## **Peartree Hill Solar Farm**

# **Environmental Statement Addendum**

Application Document Ref: EN010157/APP/8.2

July 2025

05/12/2024

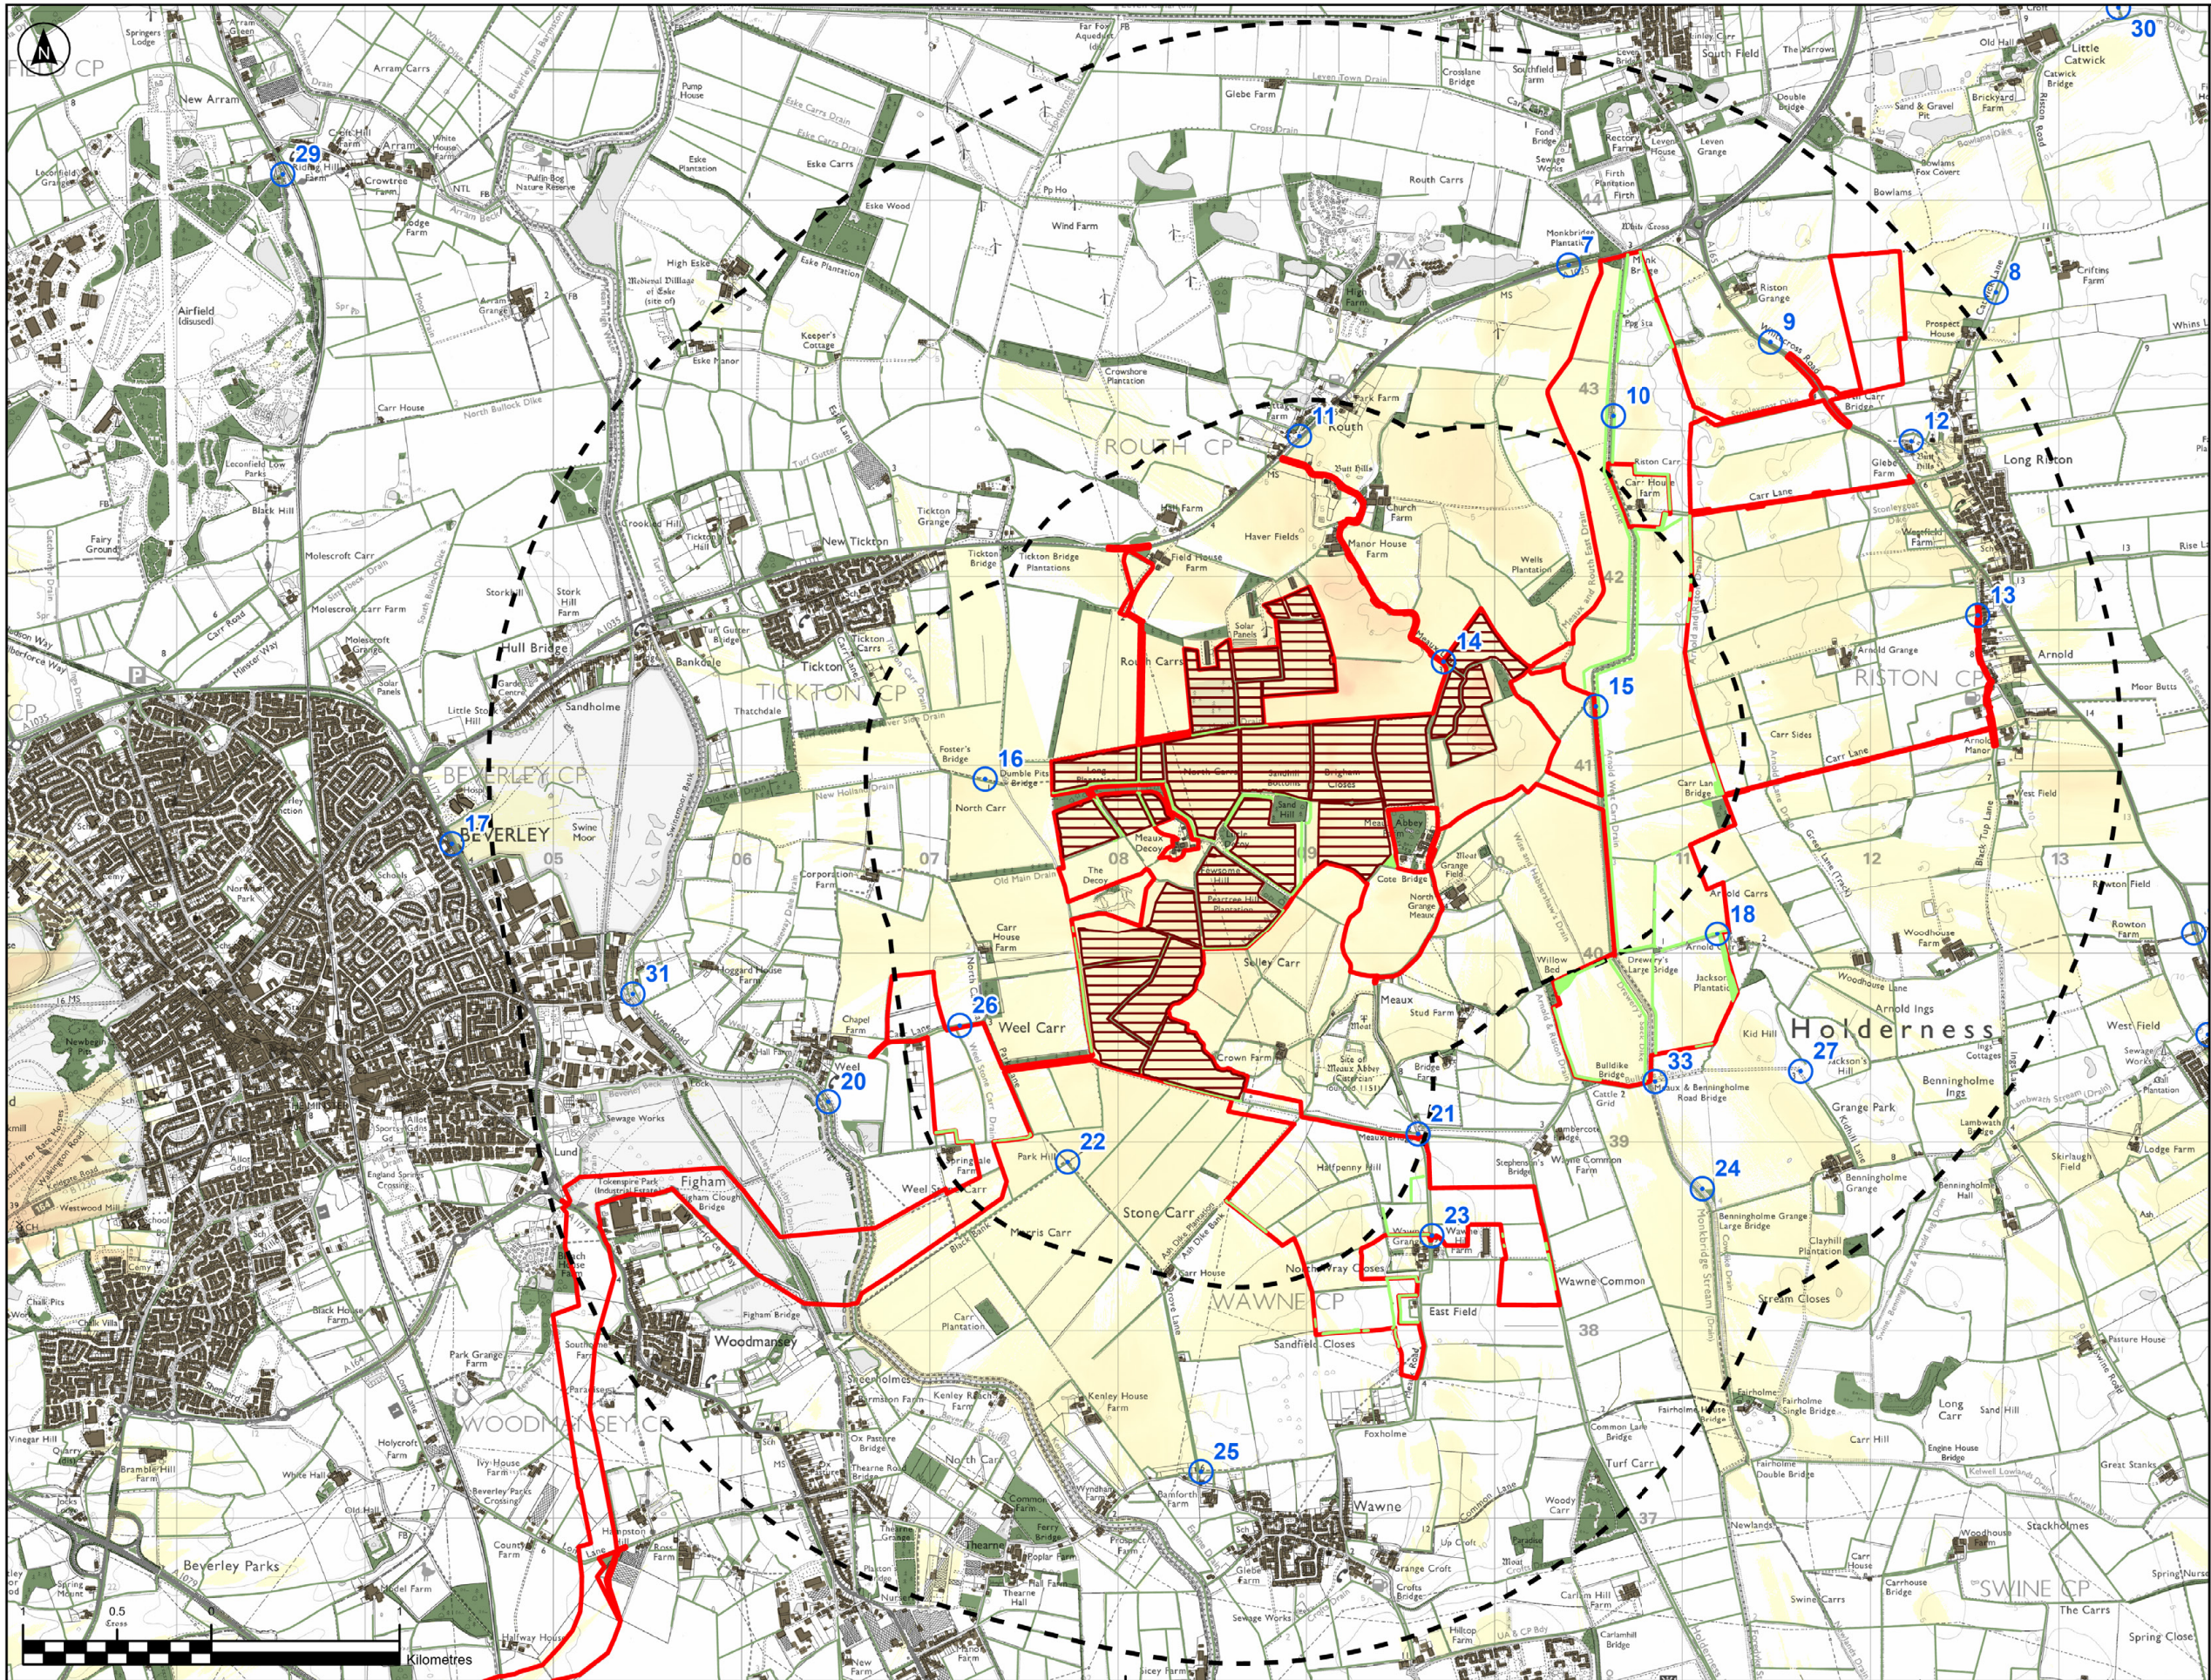
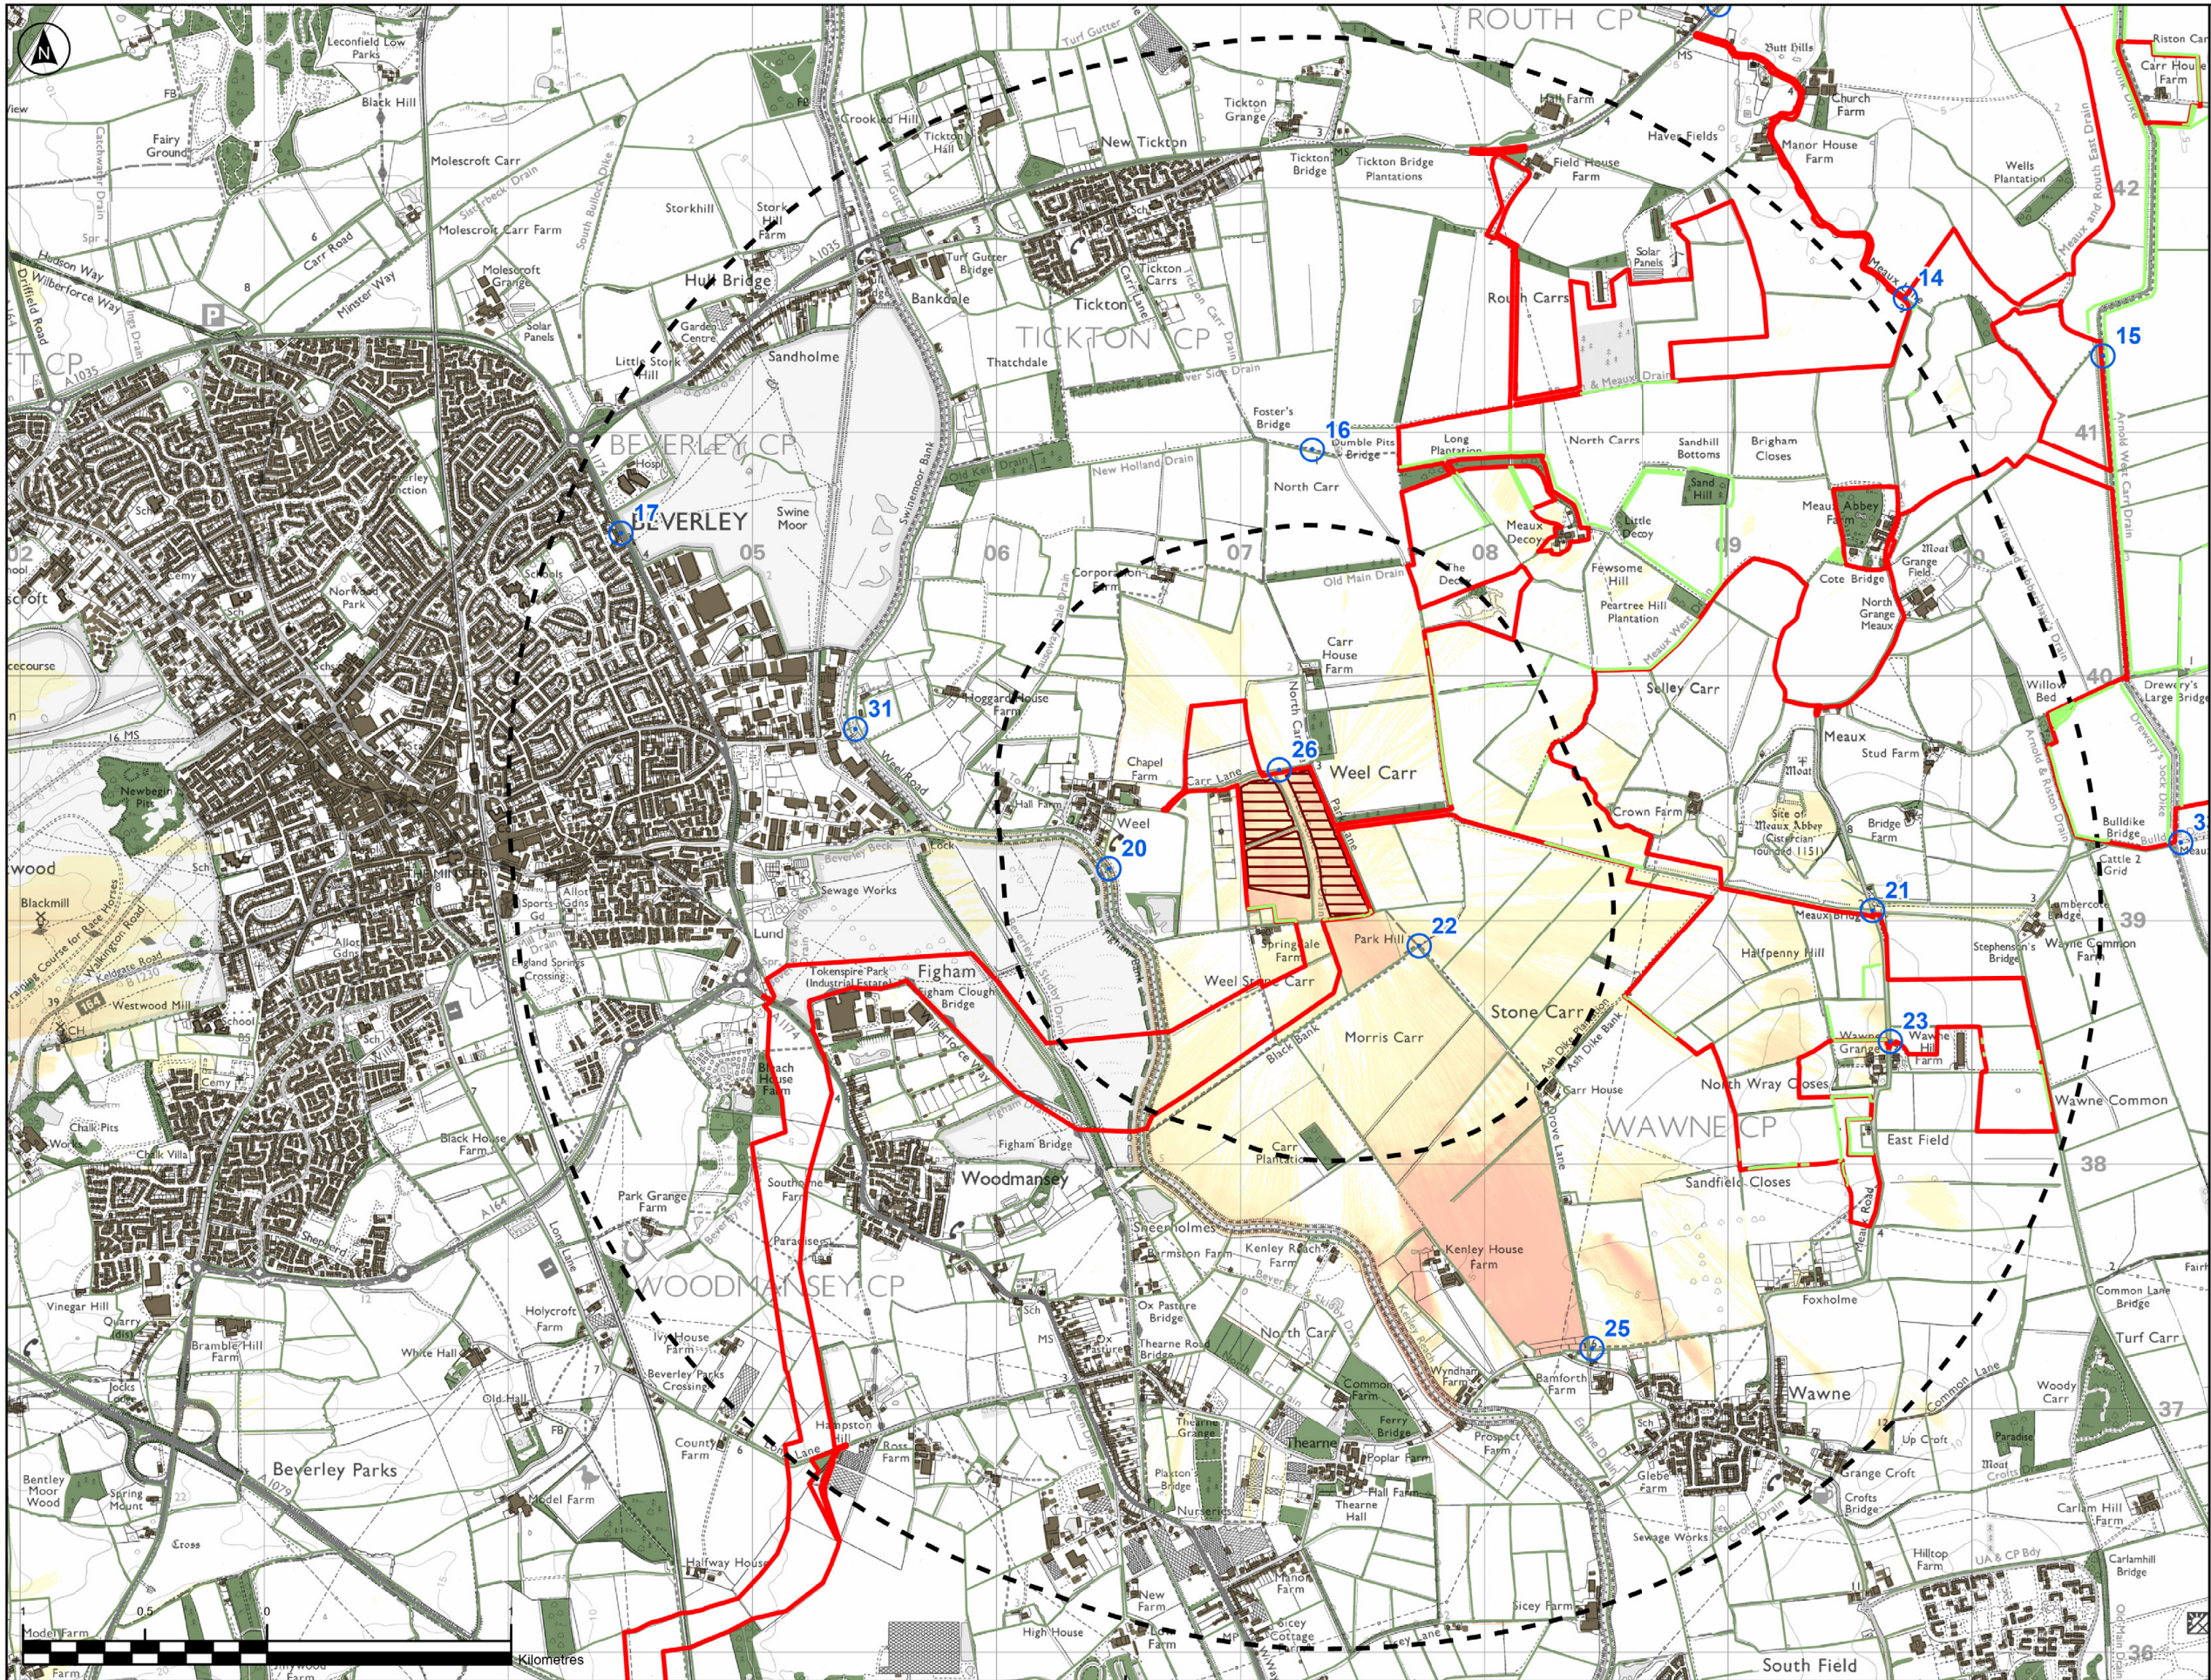
ES Volume 3, Figure 11.8: Solar PV Modules Year 10 Post Mitigation ZTV [APP-079]	<p>Figure 11.8 requires amendment to reflect the removal of a section of solar array from Land Area B as part of change/correction 1.</p> <p>Figure 11.8 also requires amendment to reflect the removal of plots 10-4, 10-5 and 10-6 as part of change/correction 2.</p>	
ES Volume 3, Figure 12.1: Study Area for Noise – Construction and Decommissioning [APP-080]	Figure 12.1 requires amendment to reflect the removal of plots 10-4, 10-5 and 10-6 as part of change/correction 2.	
ES Volume 3, Figure 12.2: Study Area for Noise – Operation (including Maintenance) [APP-081]	Figure 12.2 requires amendment to reflect the removal of plots 10-4, 10-5 and 10-6 as part of change/correction 2.	
ES Volume 3, Figure 12.3: Baseline Noise Monitoring Locations [APP-082]	Figure 12.3 requires amendment to reflect the removal of plots 10-4, 10-5 and 10-6 as part of change/correction 2.
